# Kittitas County Community Development Services

December 13<sup>th</sup>, 2005

RE: R.V. Town Short Plat (SP-05-76)

RV TOWN SHORT PLAT PART OF SECTION 11, T. 20 N., R. 13 E., W.M. KITTITAS COUNTY, WASHINGTON

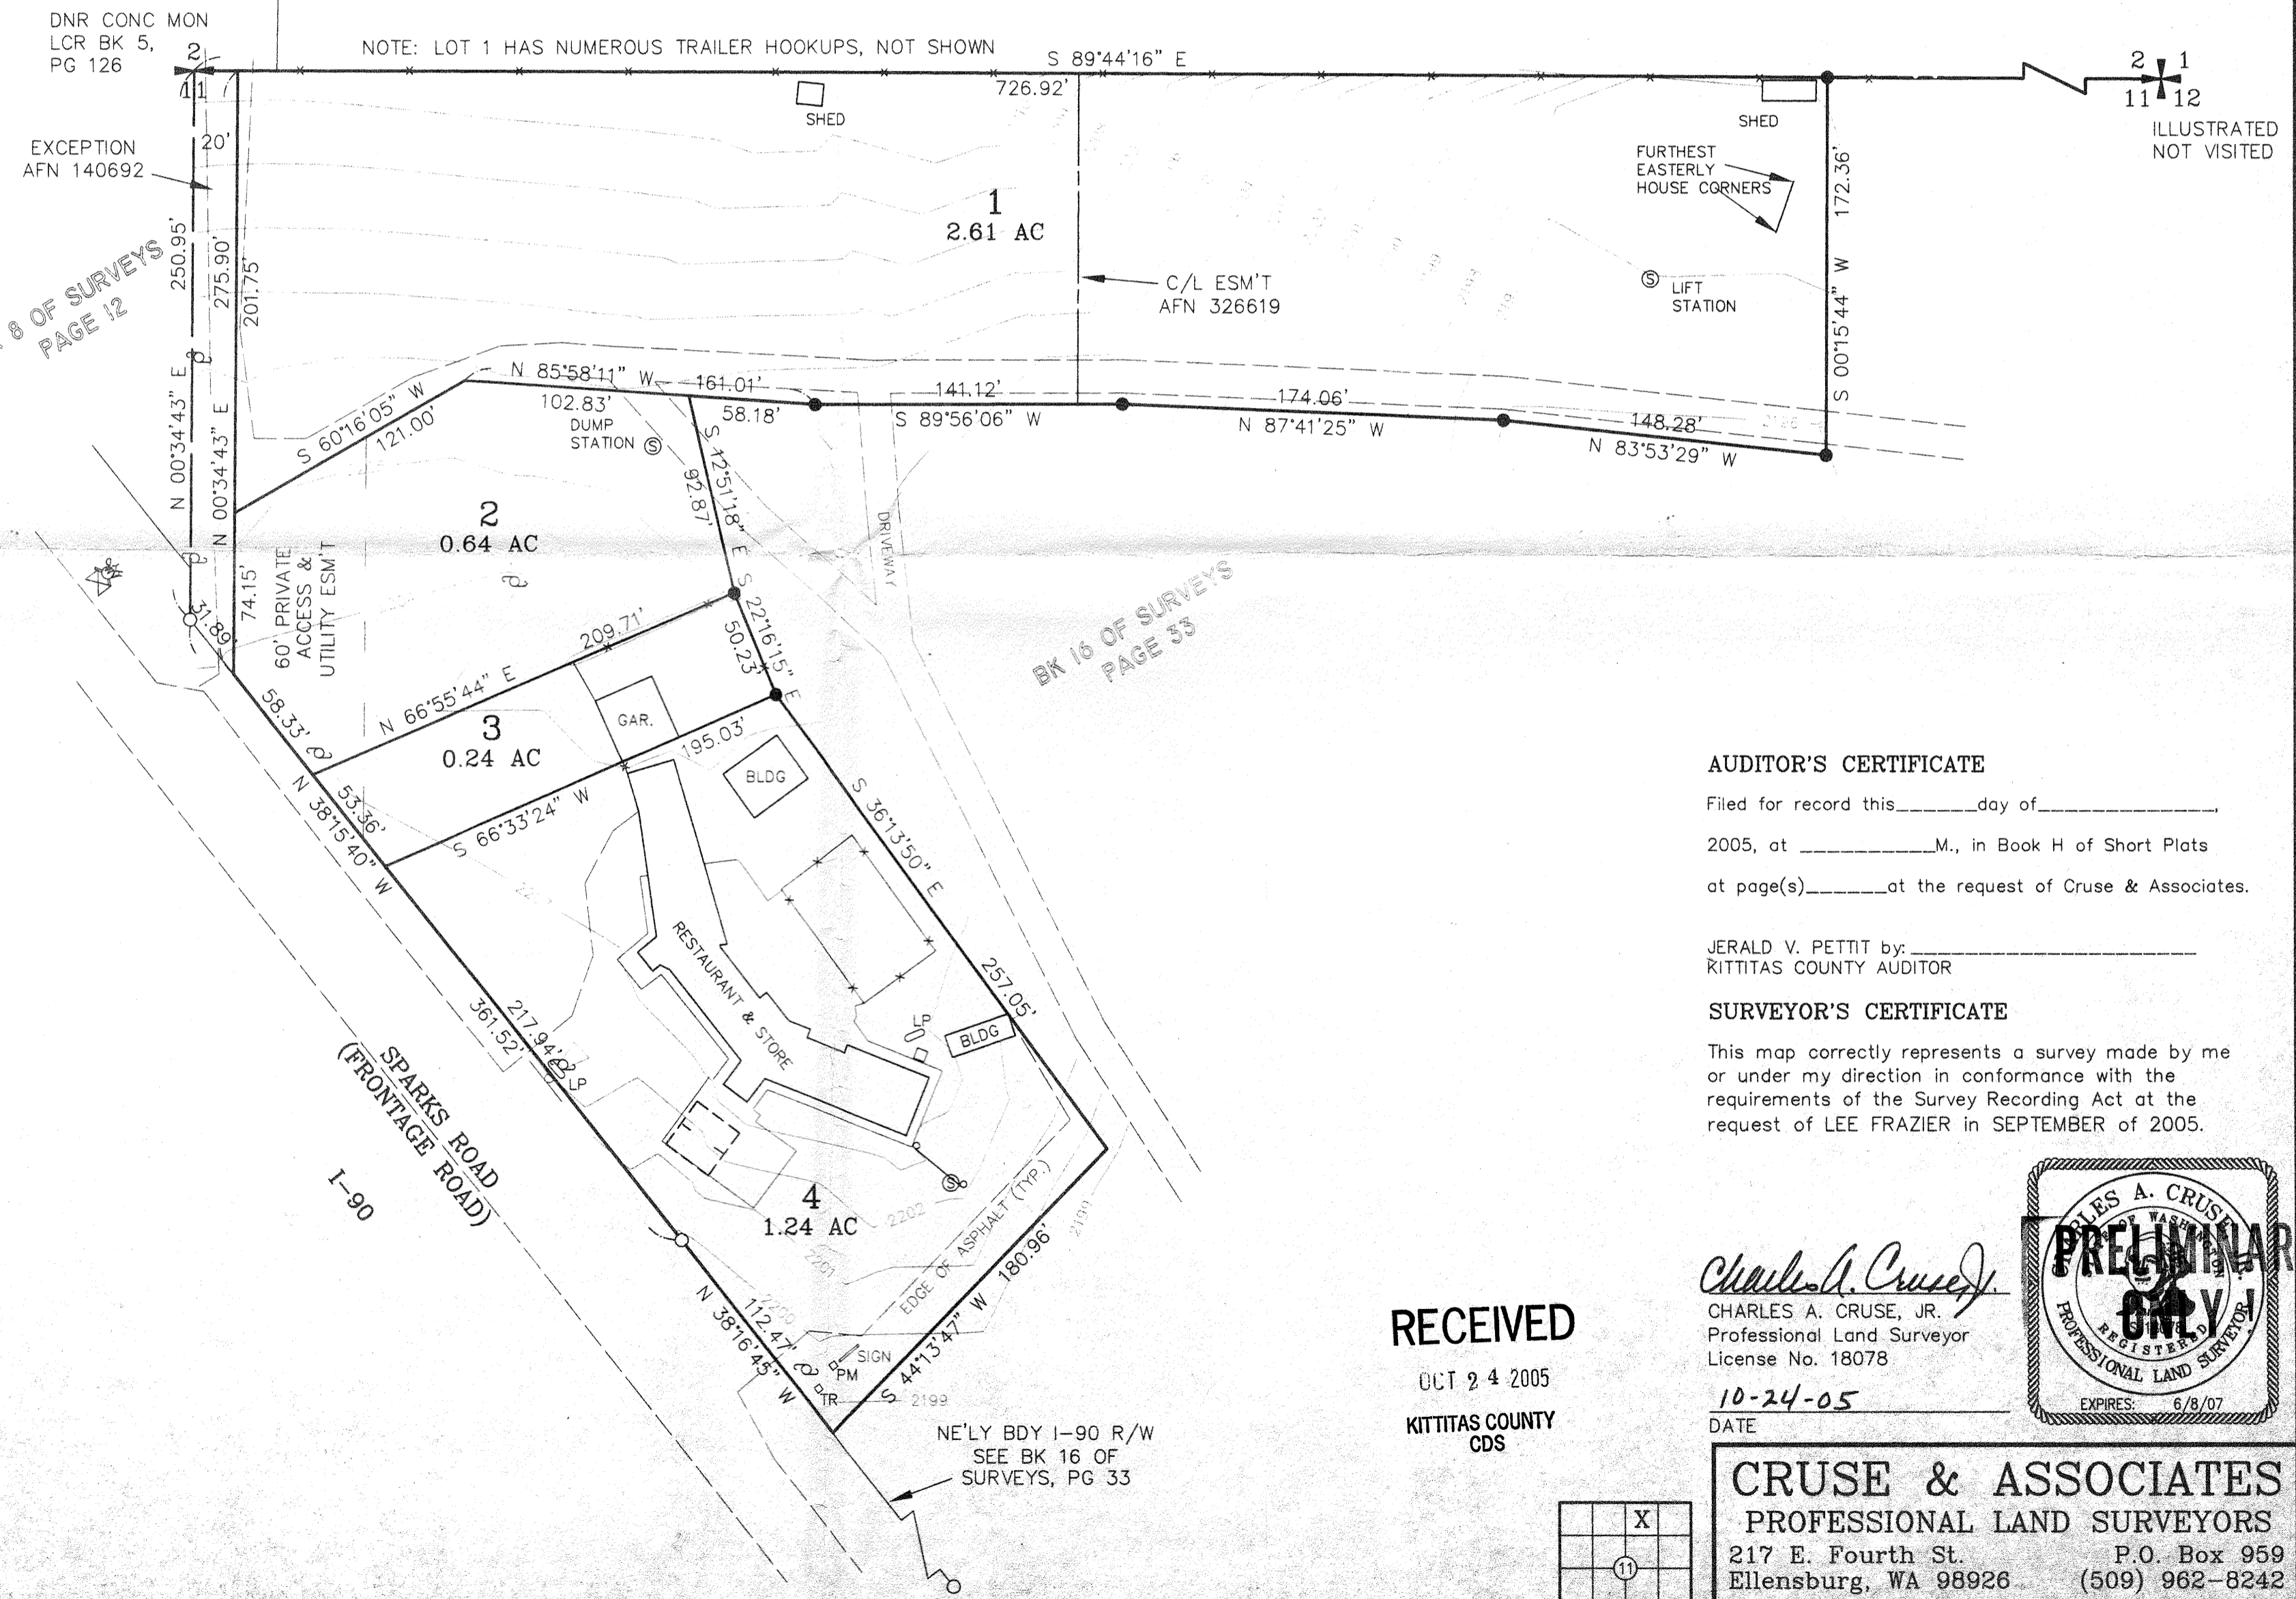
1. Both sheets shall reflect the short plat number SP-05-76.
2. Our department has approved and released the RV Town/Lee Frazier BLA on November 3<sup>rd</sup>, 2005. Please provide proof that the RV Town/ Lee Frazier BLA has been submitted to the Assessors Department prior to final approval (a copy of the BLA form with the Assessors date stamp is accepted).
3. Attached you will find additional conditions from the Kittitas County Department of Public Works and KC Environmental Health. **Please see those documents for required plat notes and information on issues needing completion before final approval of this short plat.**
